MMC: FW: Shaws TCP (CMP) - Status

Hi Nell – The following is a status update of previous comments based upon new information submitted by the applicant. Thanks

Maine Medical Center Site Enabling PH2		Phase 1 Work Zone Traffic Control Plan		FIGURE <b>1A</b>
Shaw Brothers Construction, Inc. 341 Mosher Road, P.O. Box 69 Gorham, Maine 04038 (207) 839-2552				
		DRAWN: M.E.	DATE: 4/30/19	
		DESIGNED: -	SCALE: 1"=100'	
		CHECKED: -	FILE: -	
		FILE LOC: -

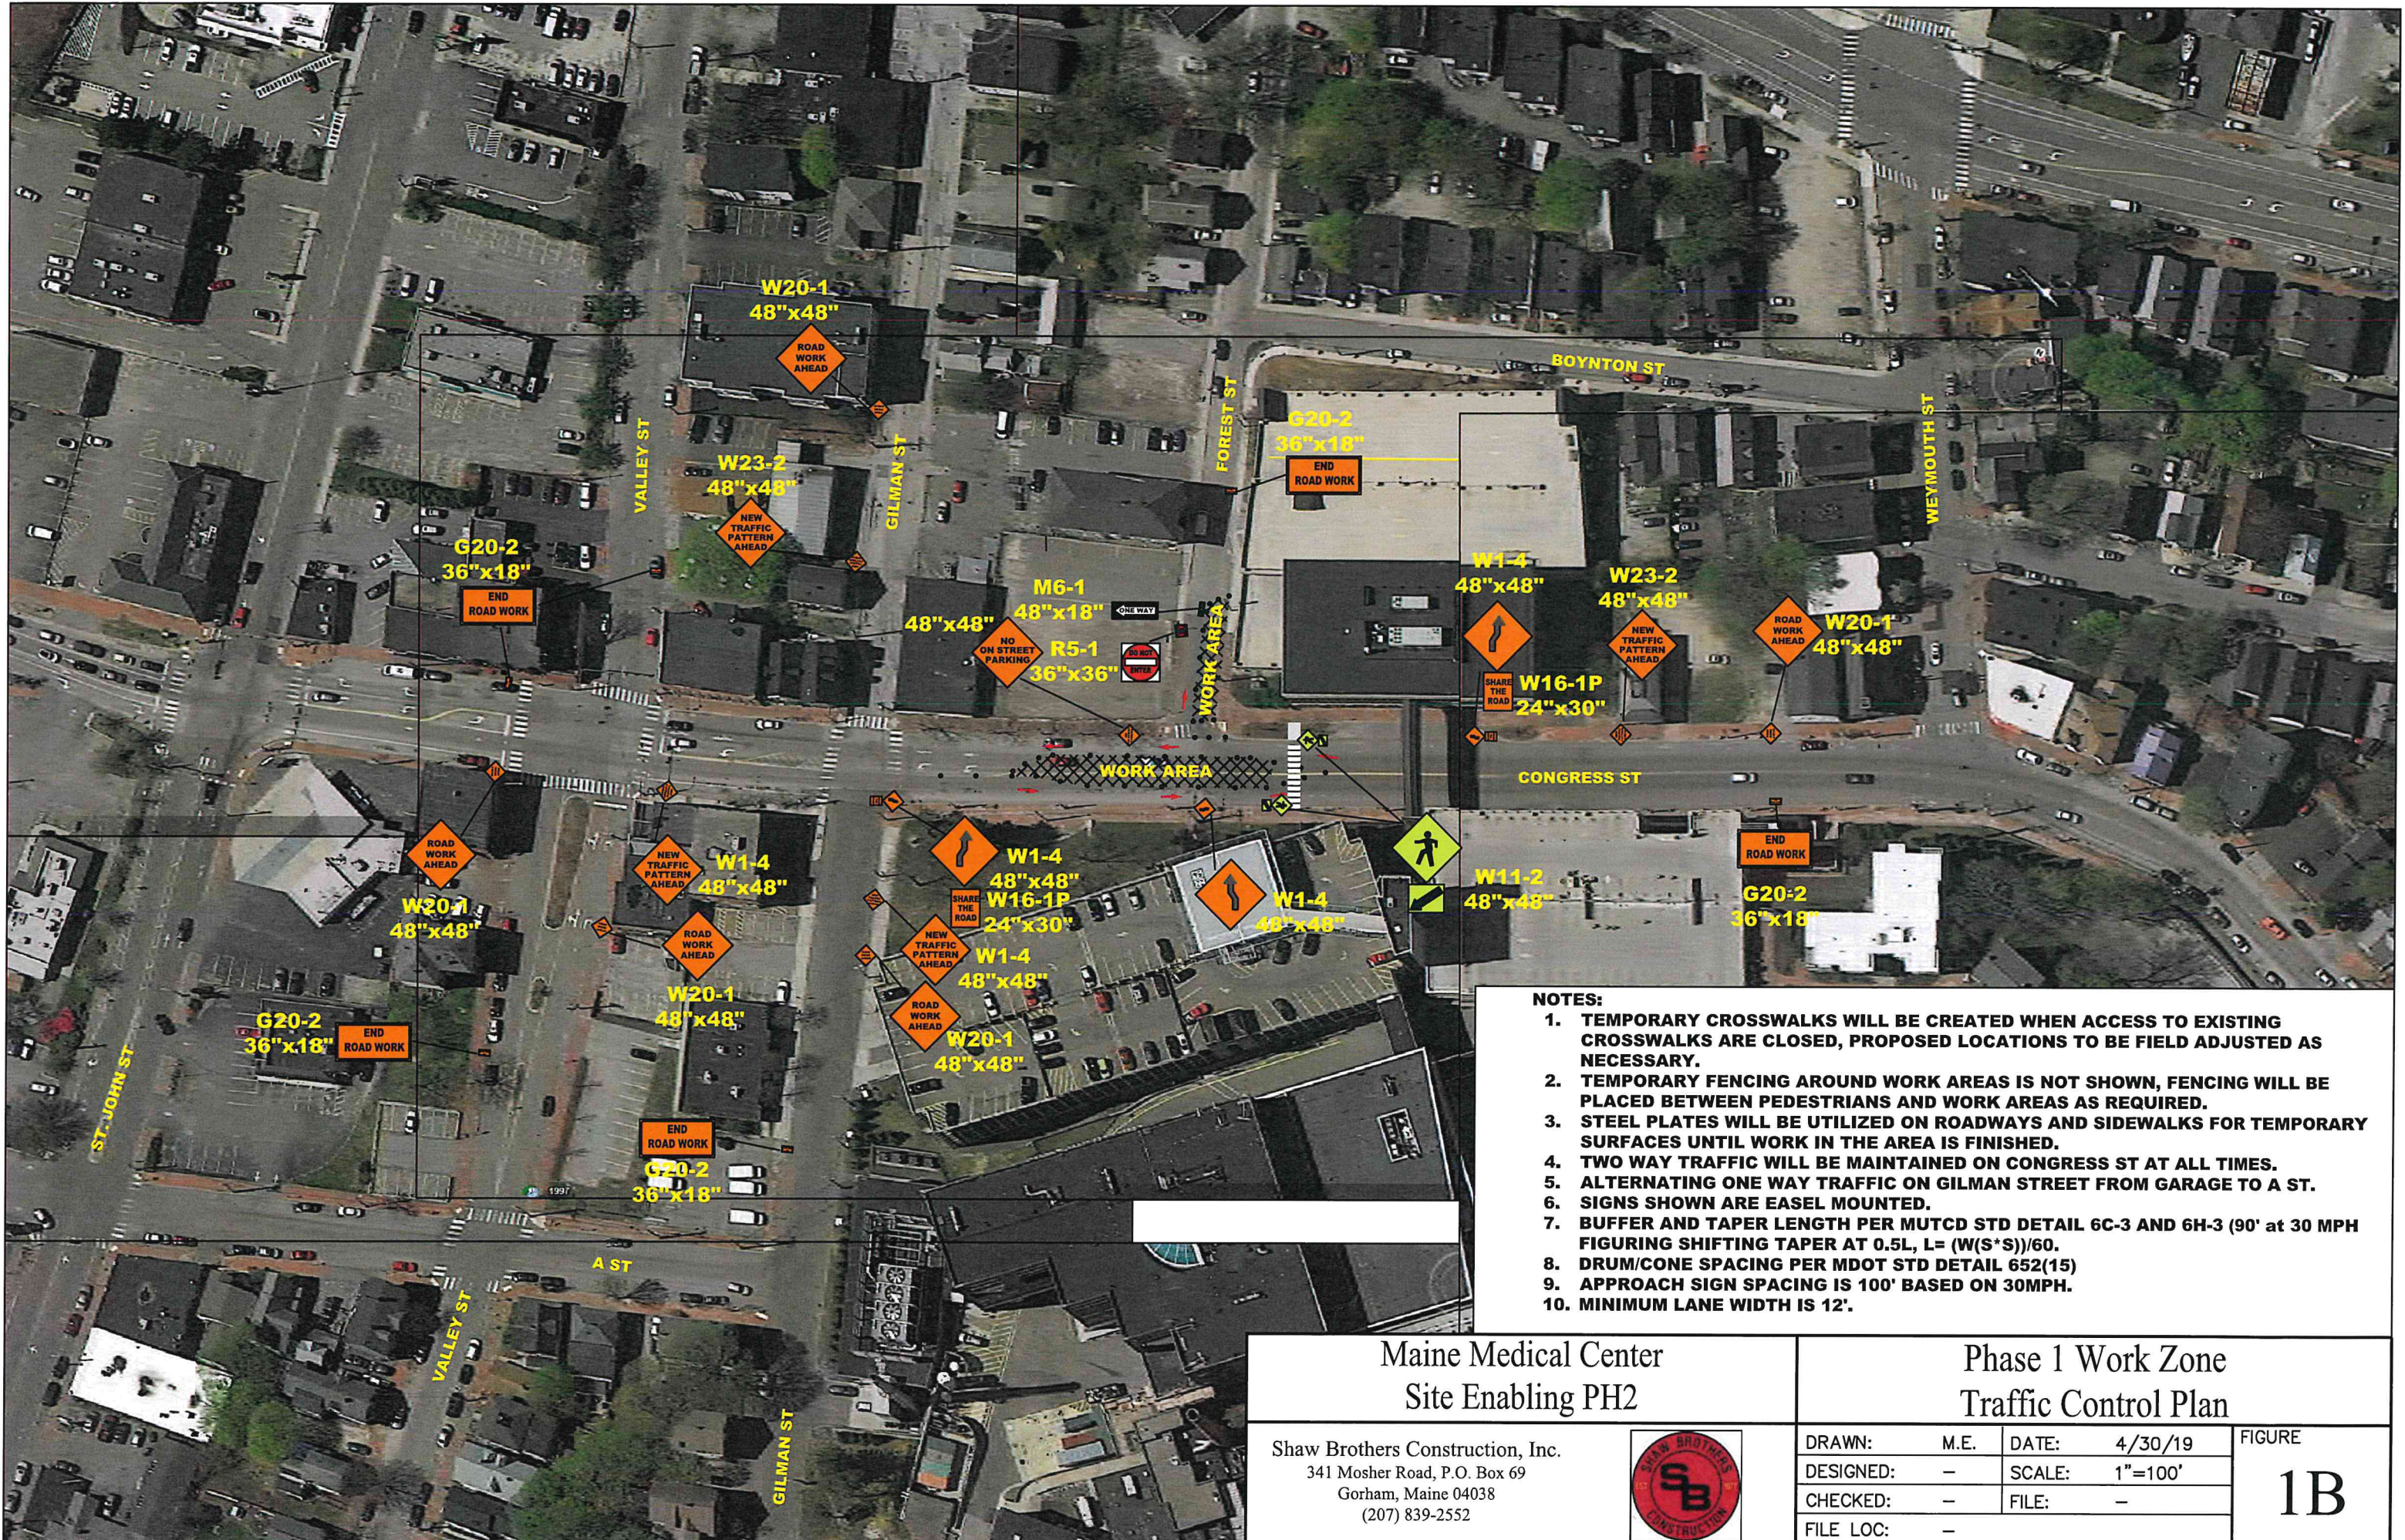
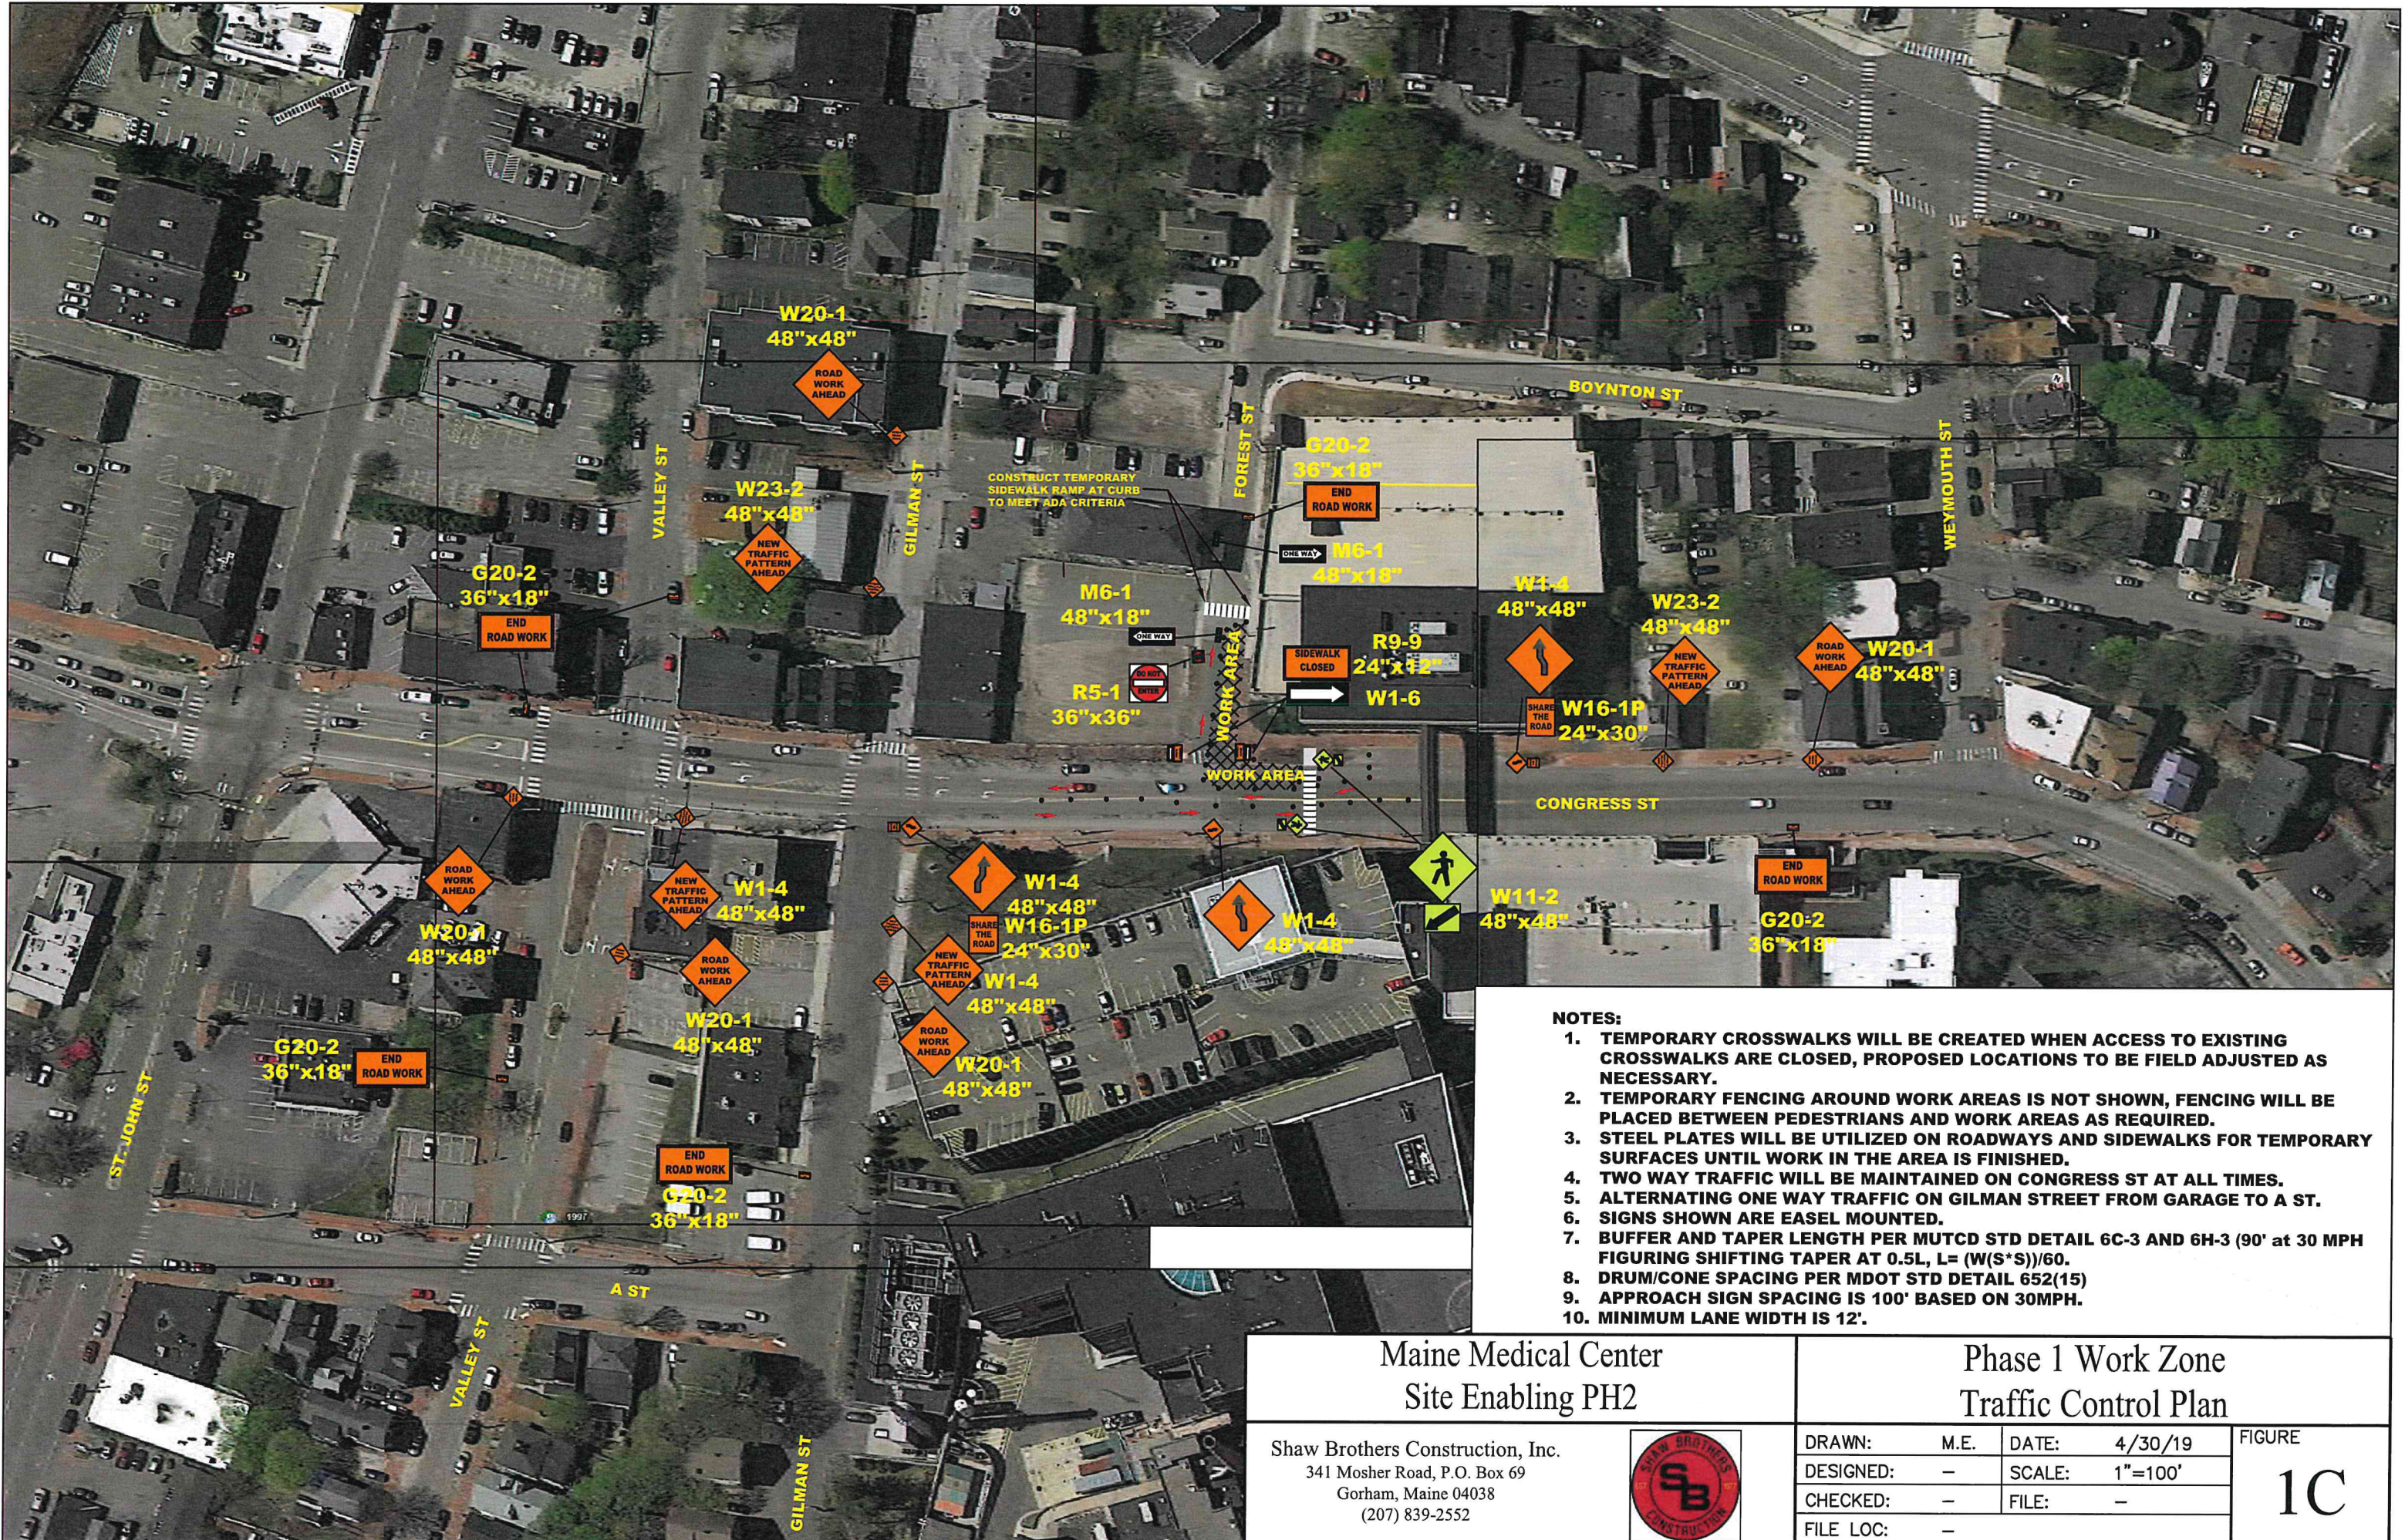
- Provide taper calculations for lane shifts (for all phases). **Provided. I have no further comment**

Maine Medical Center Site Enabling PH2		Phase 1 Work Zone Traffic Control Plan		FIGURE <b>1B</b>
Shaw Brothers Construction, Inc. 341 Mosher Road, P.O. Box 69 Gorham, Maine 04038 (207) 839-2552				
		DRAWN: M.E.	DATE: 4/30/19	
		DESIGNED: -	SCALE: 1"=100'	
		CHECKED: -	FILE: -	
		FILE LOC: -

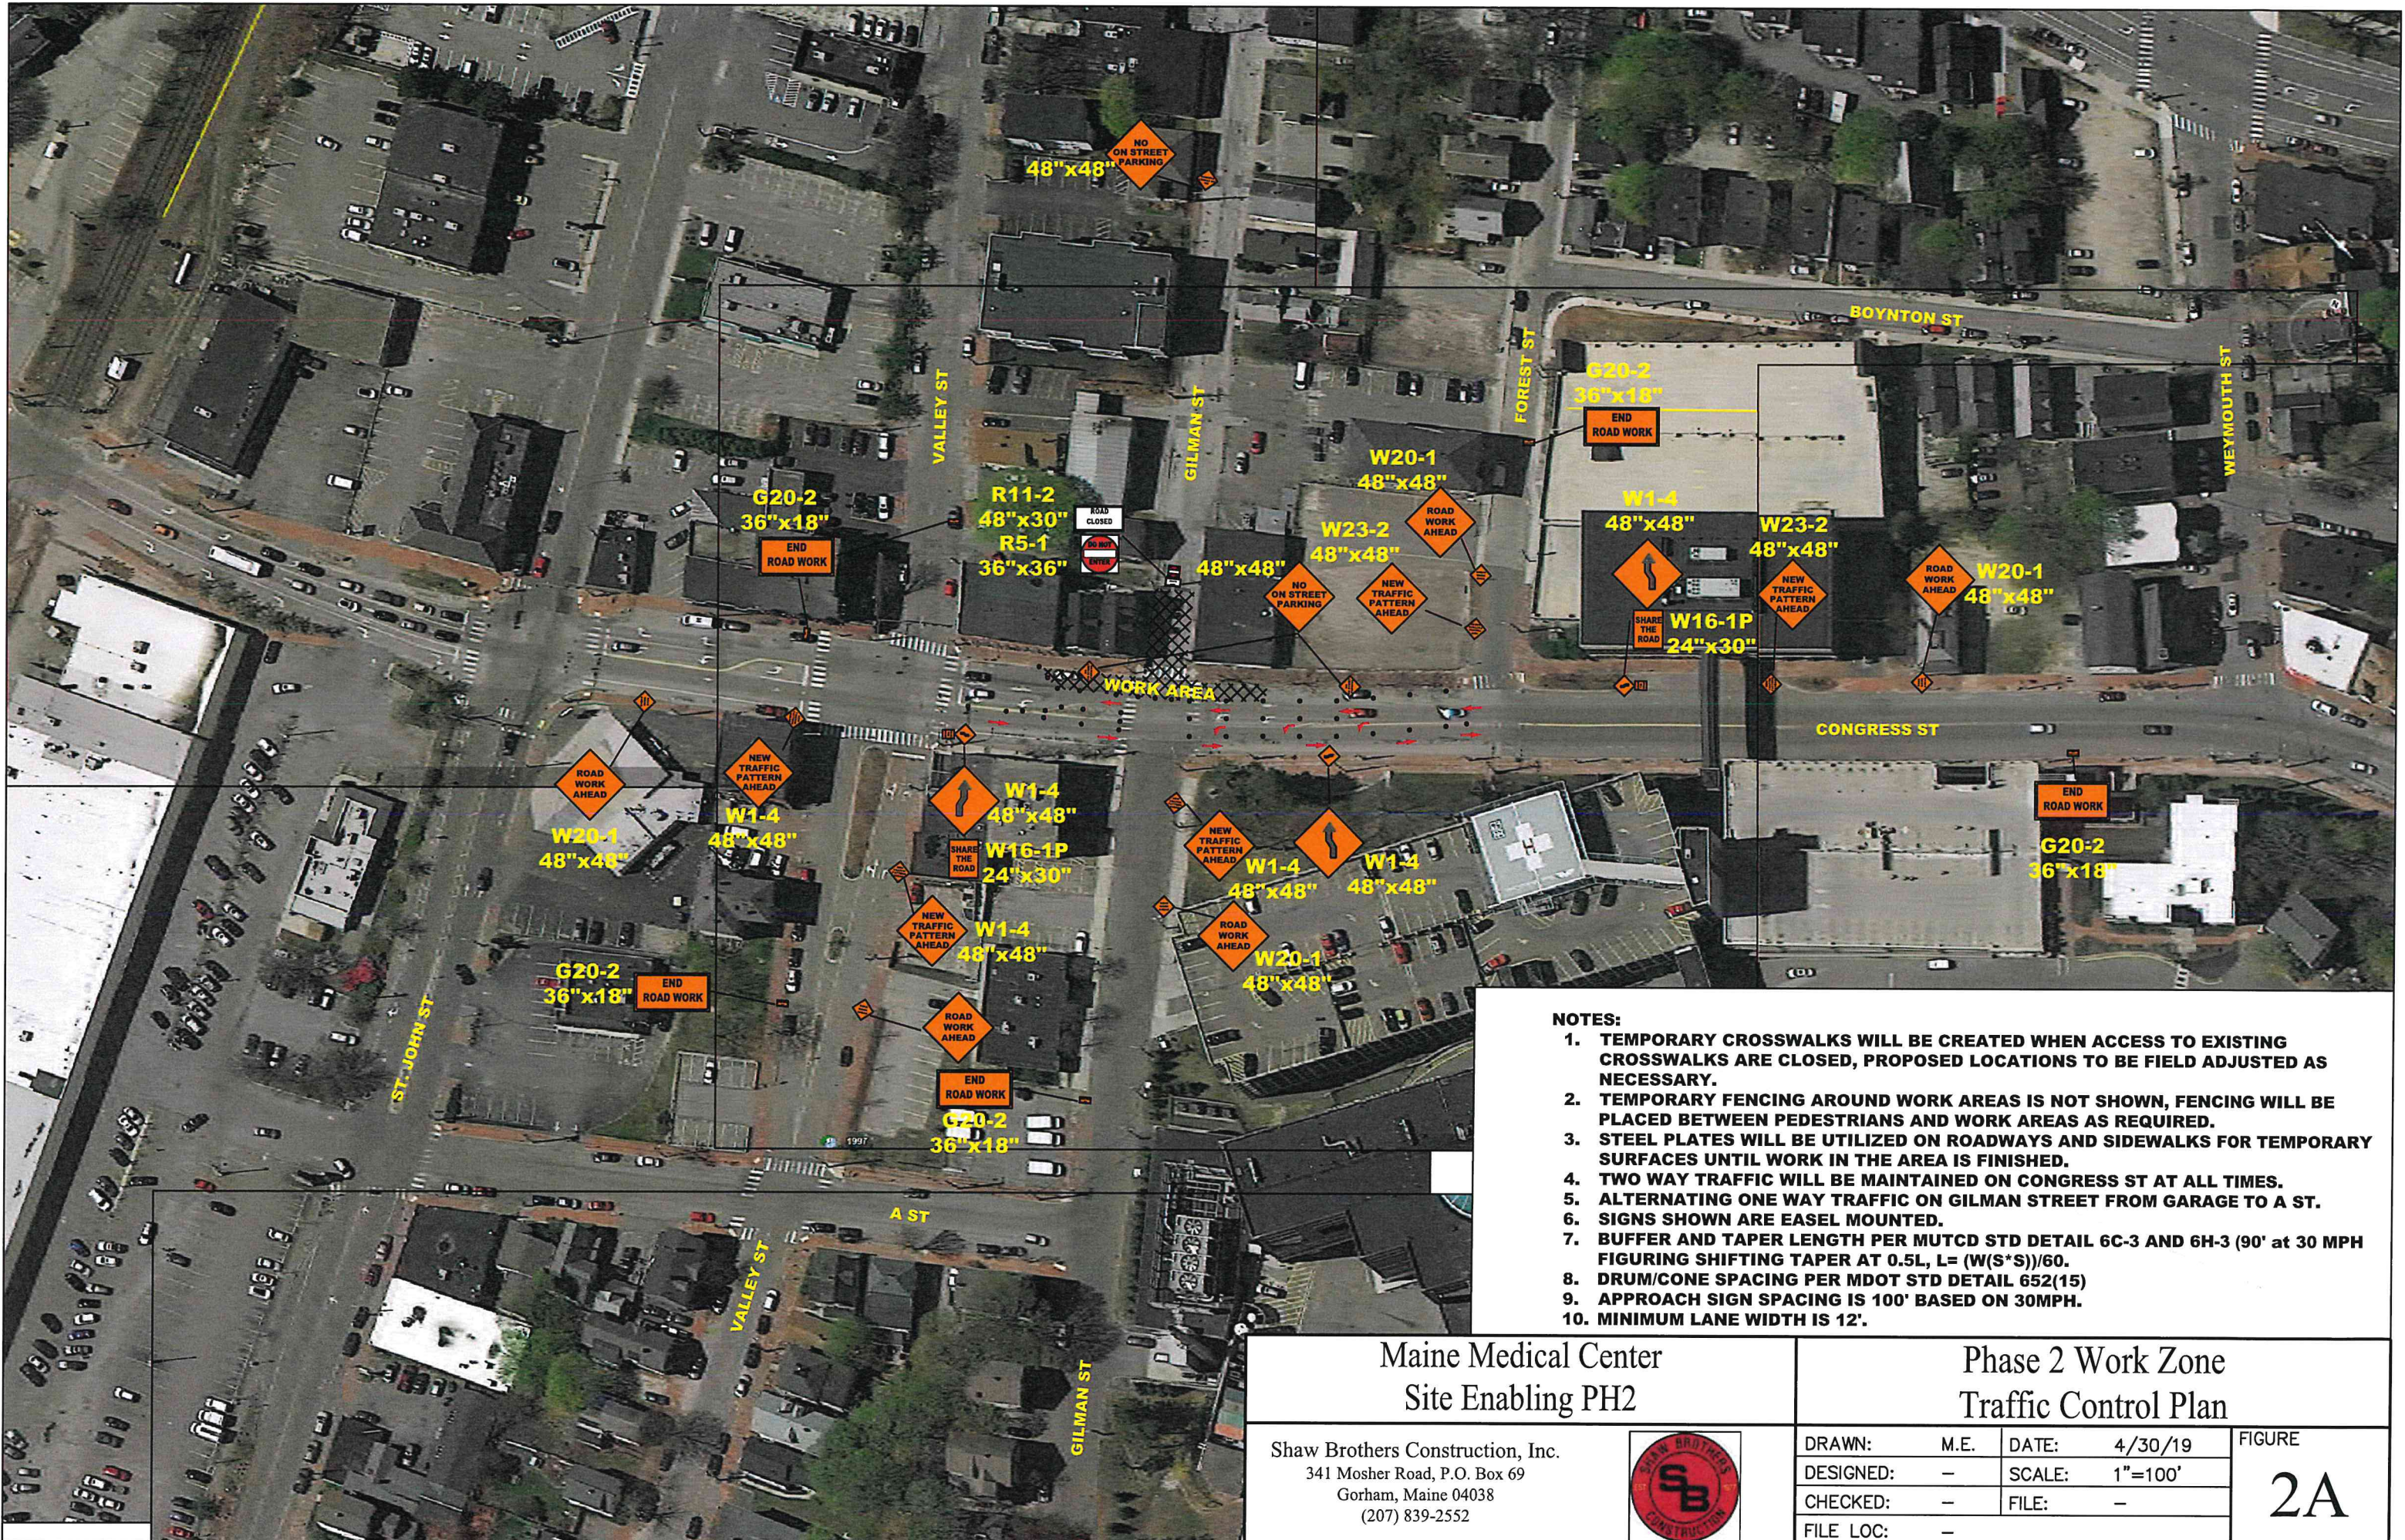
- Conflicting signs exiting garage on Forest should be addressed. **Incorporated. I have no further comment.**
- Could a few of the on-street parking spaces be returned for use in front of Salvage BBQ. **To be determined in the field. I find this acceptable with the understanding that parking should be returned when feasible.**
